Subject: 2026/90406 at location Land north of, 344, Leymoor Road, Golcar, Huddersfield, HD7 4QL

Please ecological commentary below:

**Proposed Block Plan**

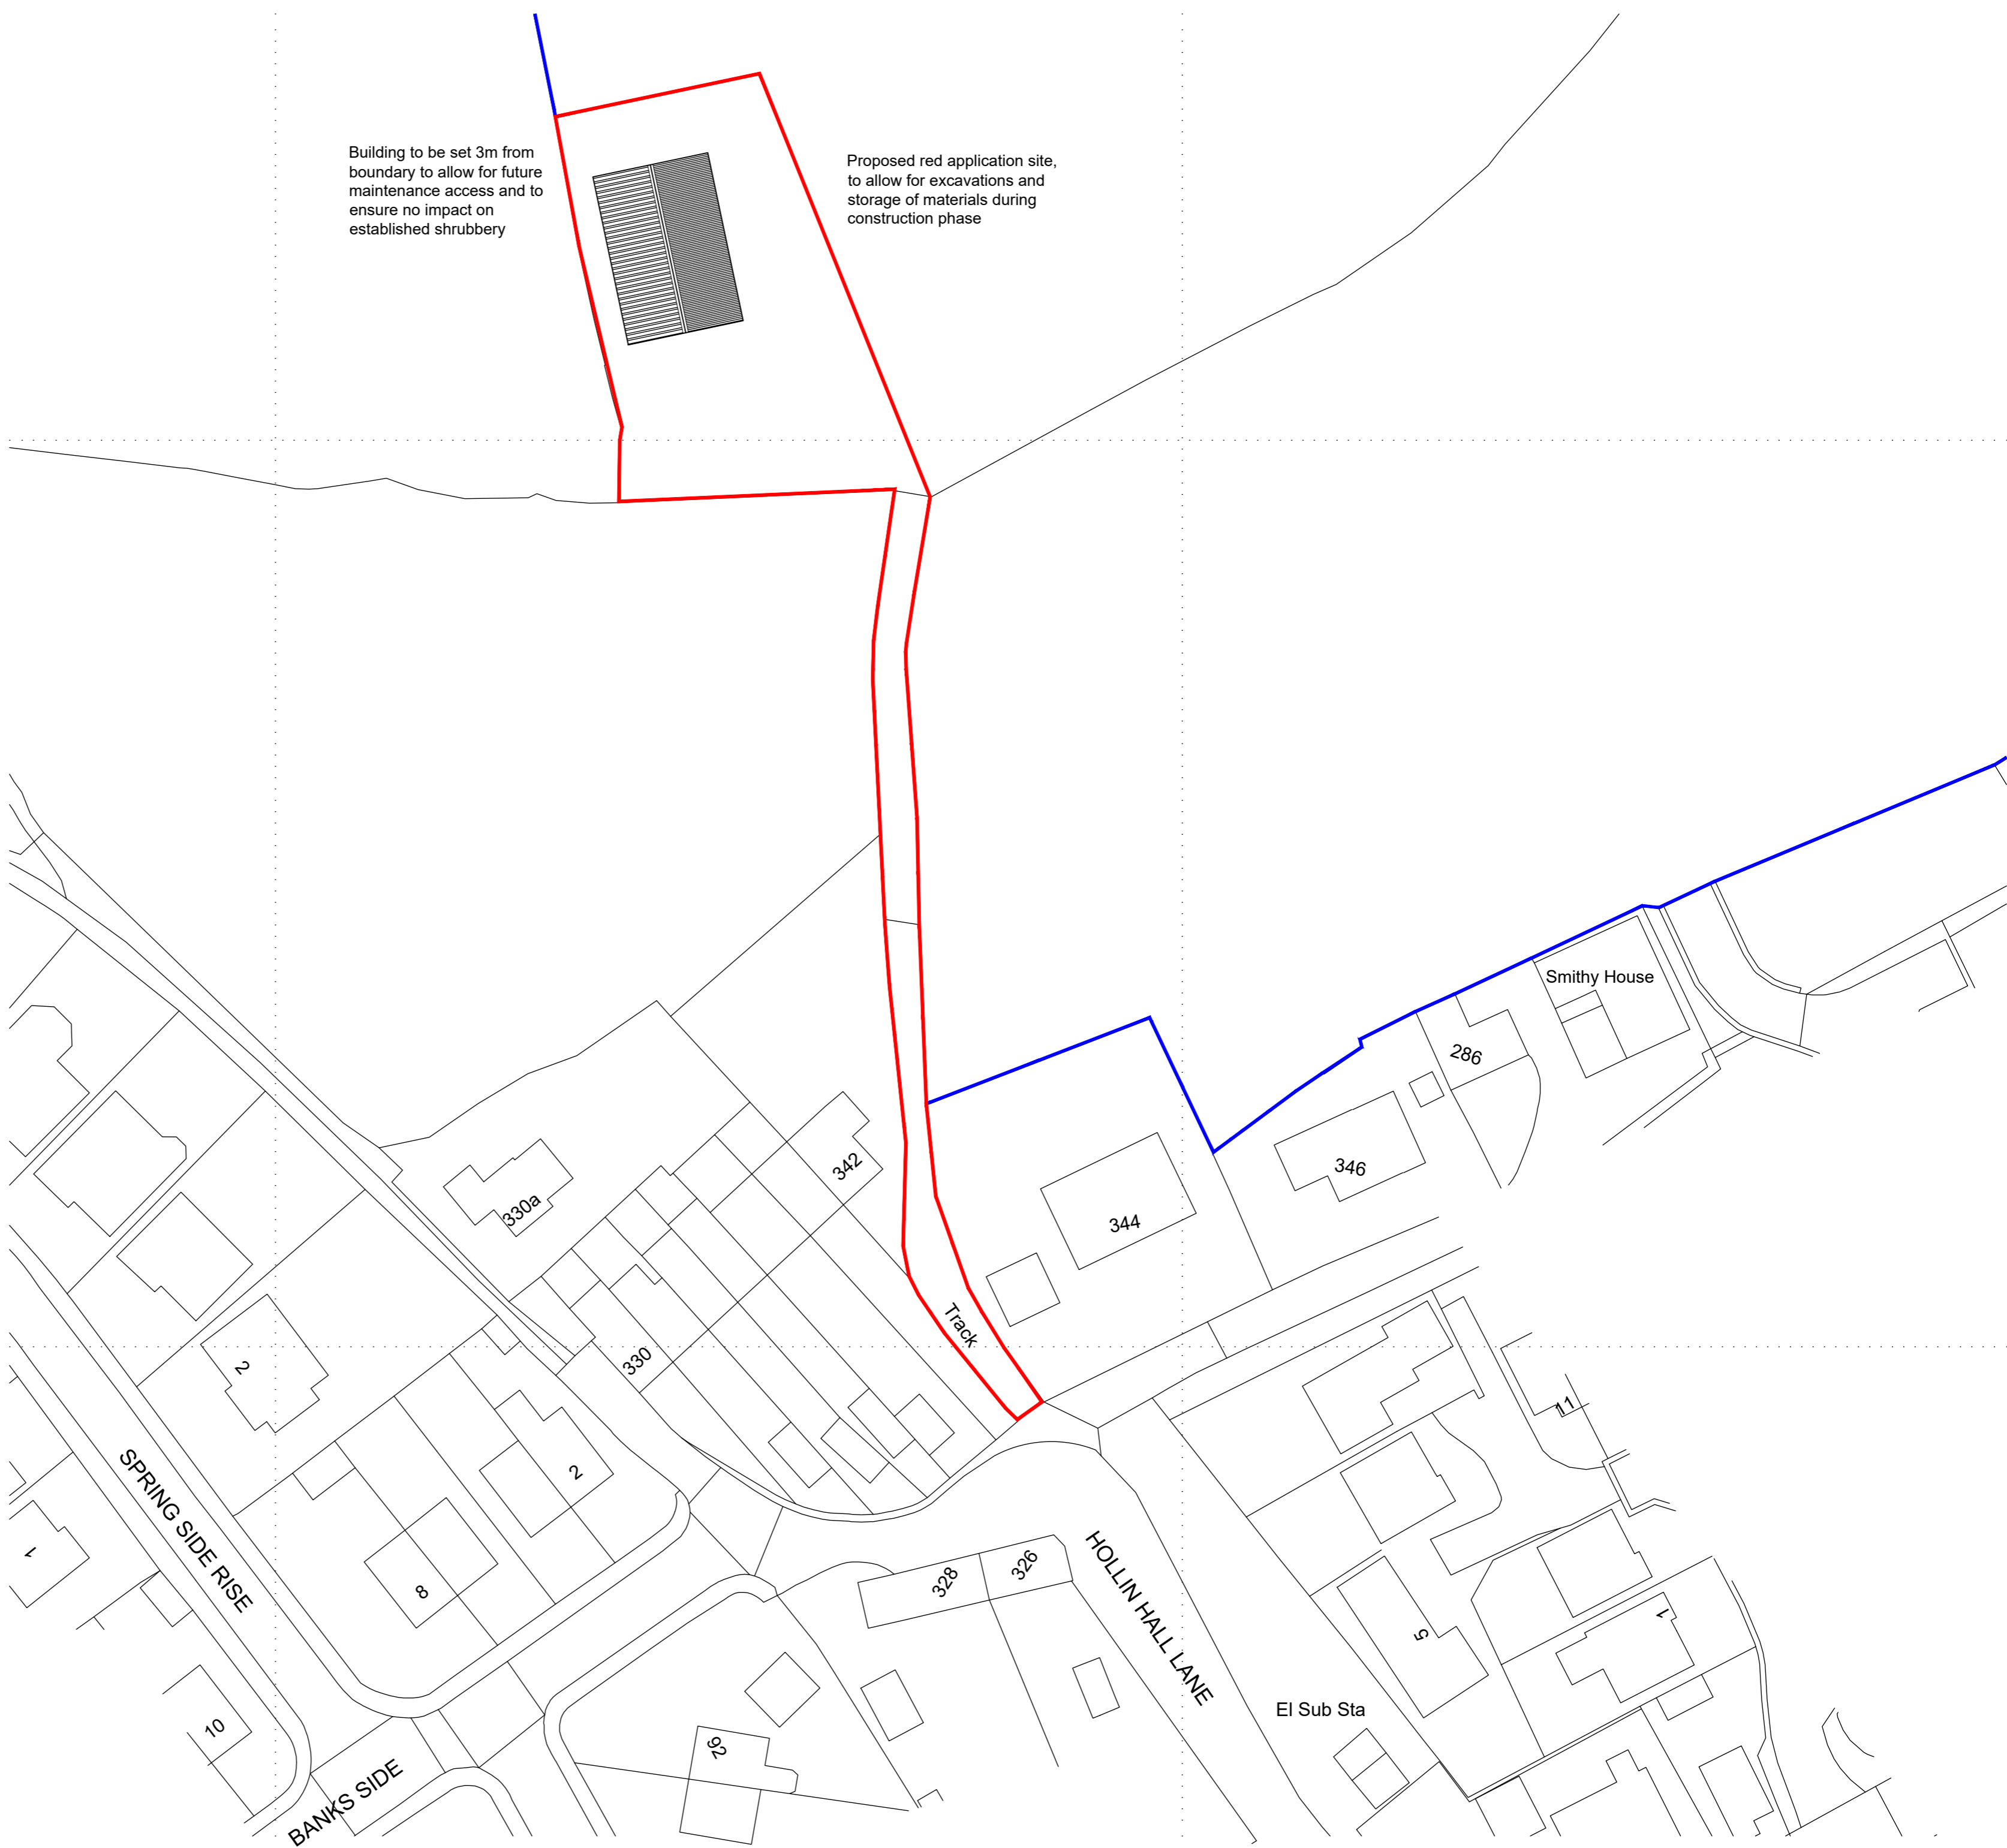
There are also a number of tree and hedgerows, as well as grassland within the site. The application has not considered the impacts of the site to these habitats and any species which may use them.

Further information is required prior to decision. Several records for protected and priority species and habitats are present within 1km of the site. A Preliminary Ecological Appraisal are therefore required prior to decision to assess the site habitats, the likely presence of protected and/or priority species, and the value of site habitats to protected and/or priority species.
